**EL PASO COUNTY PLANNING AND
 COMMUNITY DEVELOPMENT
 DEPARTMENT**

STORMWATER MANAGEMENT PLAN CHECKLIST

GRADING AND EROSION CONTROL PLAN CHECKLIST

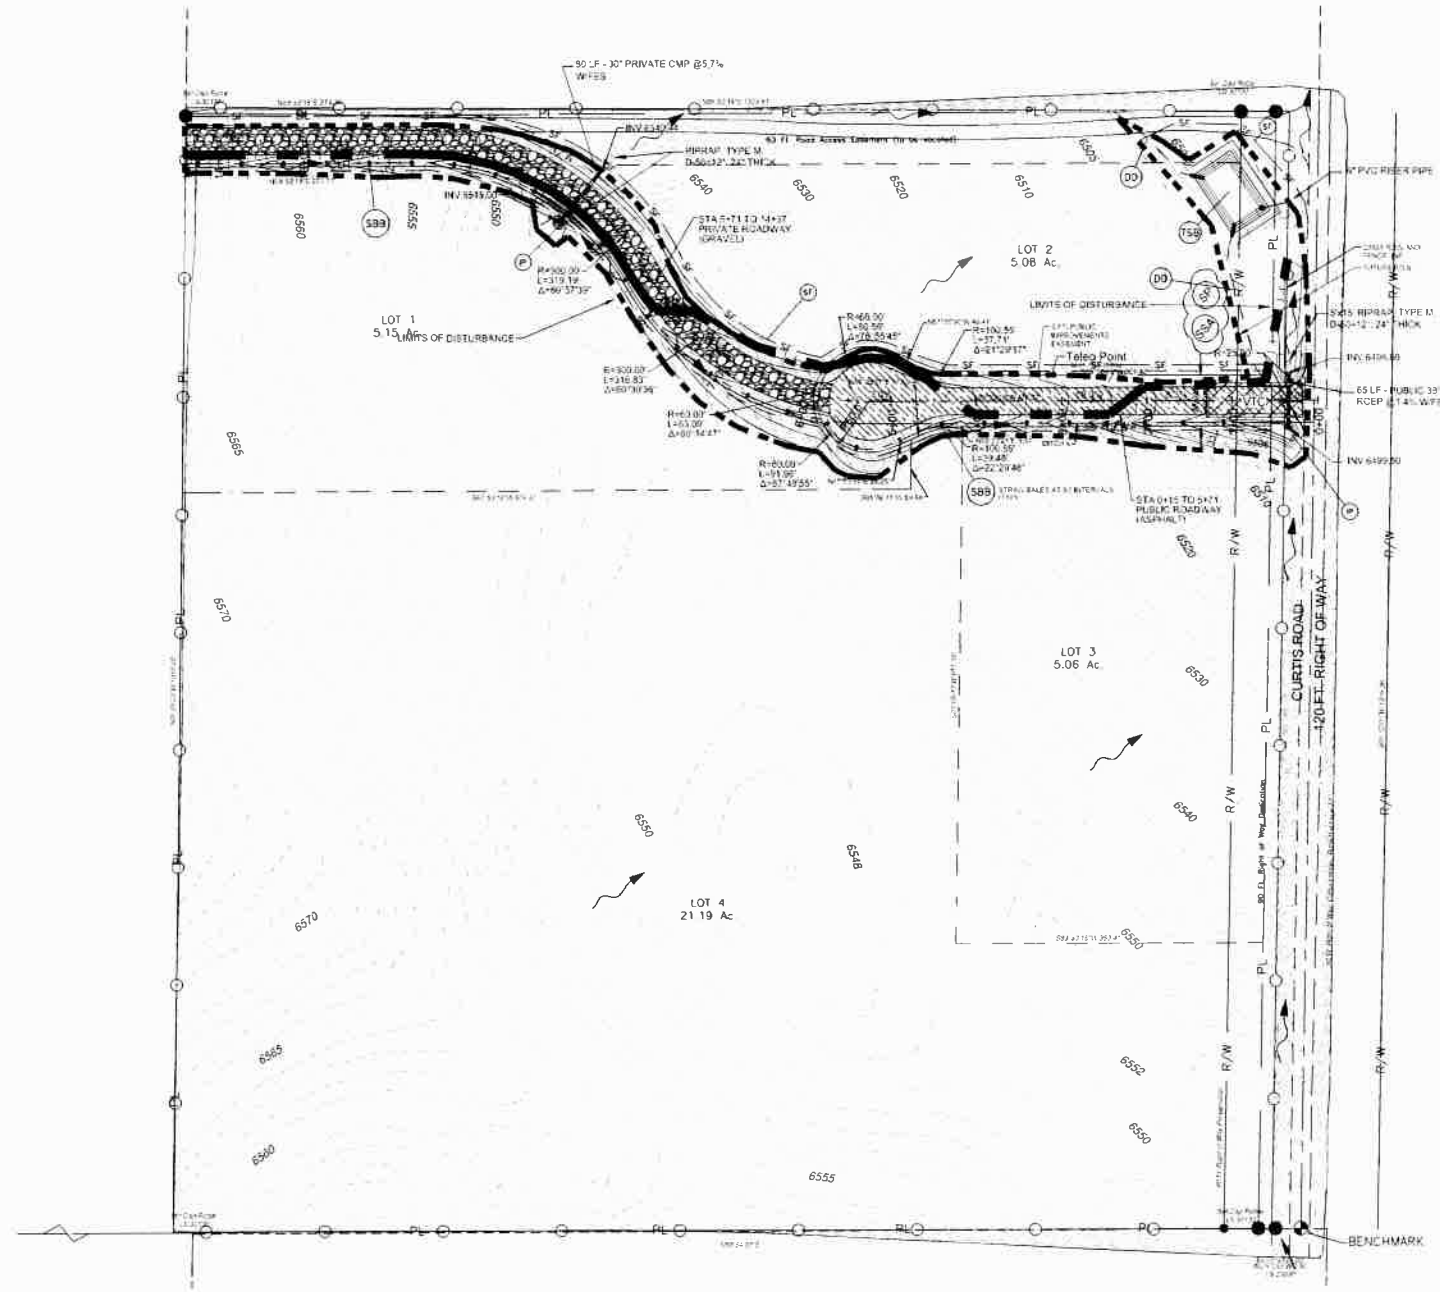
v	All proposed temporary construction control measures, structural and non-structural. Temporary construction control measures shall be identified by phase of implementation to include "initial," "interim," and "final" or shown on separate phased maps identifying each phase.	✓	✓
w	Vehicle tracking provided at all construction entrances/exits. Construction fencing, barricades, and/or signage provided at access points not to be used for construction.	✓	✓
x	Temporary sediment ponds provided for disturbed drainage areas greater than 1 acre.	✓	✓
y	Dewatering operations to include locations of diversion, pump and discharge(s) as anticipated at time of design.	N/A	N/A
z	All proposed temporary construction control measure details. Custom or other jurisdiction's details used must meet or exceed EPC standards.	✓	X
